RE: Harnett County Land Use Application 06-5-14612

An Environmental Health Specialist from the Harnett County Health Department attempted to evaluate your property for the purpose of issuing an Improvement Permit. This individual was unable to evaluate your property for one or more of the following reasons.

Submitted
Plot
Plan

SURVEY FOR:
PROPOSED PLOT PLAN - LOT - 102
FOREST OAKS S/D, PHASES ONE & TWO

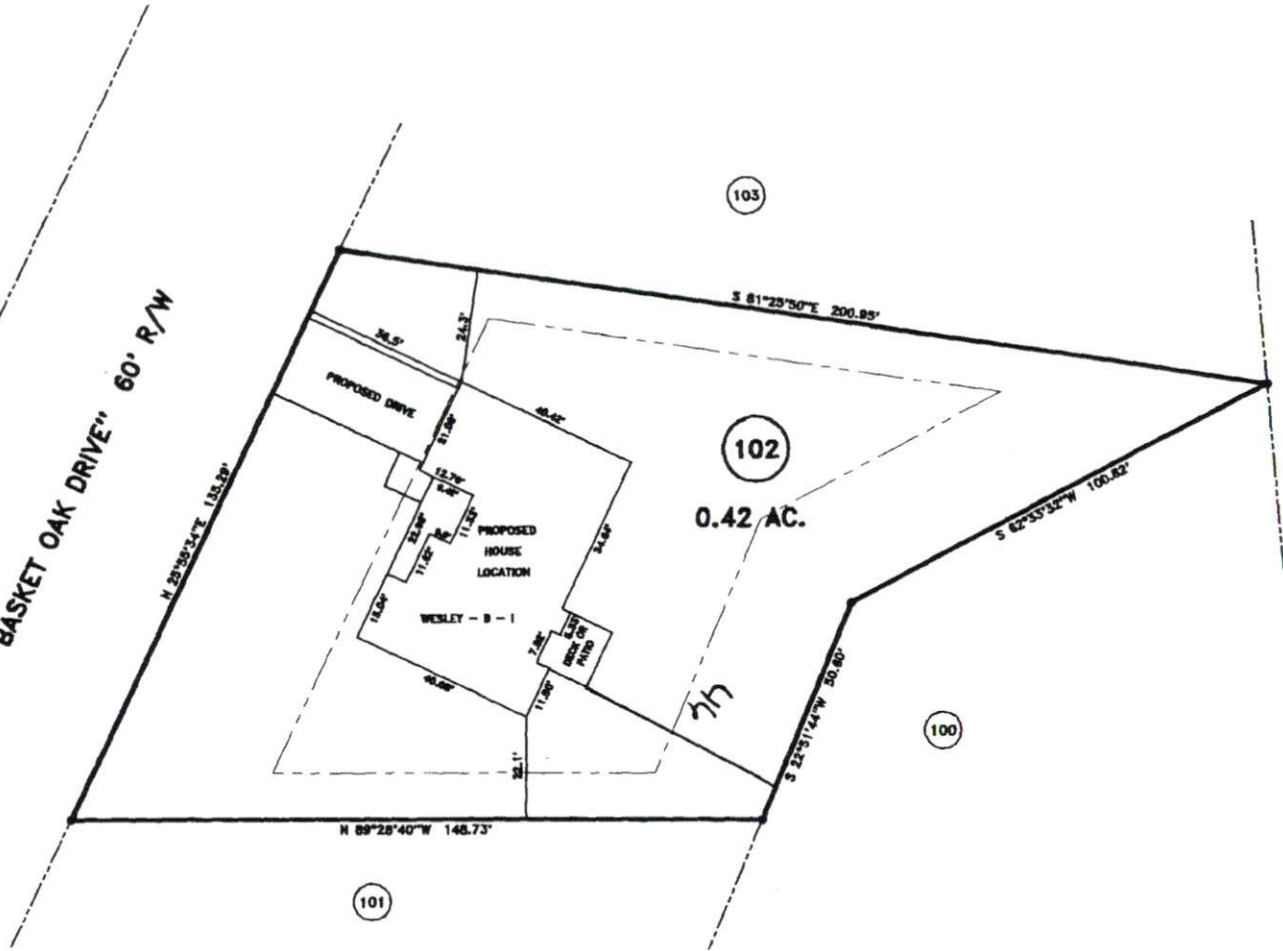
- 1. Property lines/corners not marked or labeled
- 2. House corners not marked or labeled
- 3. Directions not clear to property
- 4. Property needs brush or vegetation removed
- 5. Backhoe pits required
- 6. Other *See attached sheet. Plot plan does not match what is staked on the ground.*

What is STAKED
on the ground

Which one is correct.

Please send me the correct plot plan or stake
correct lot on the ground.
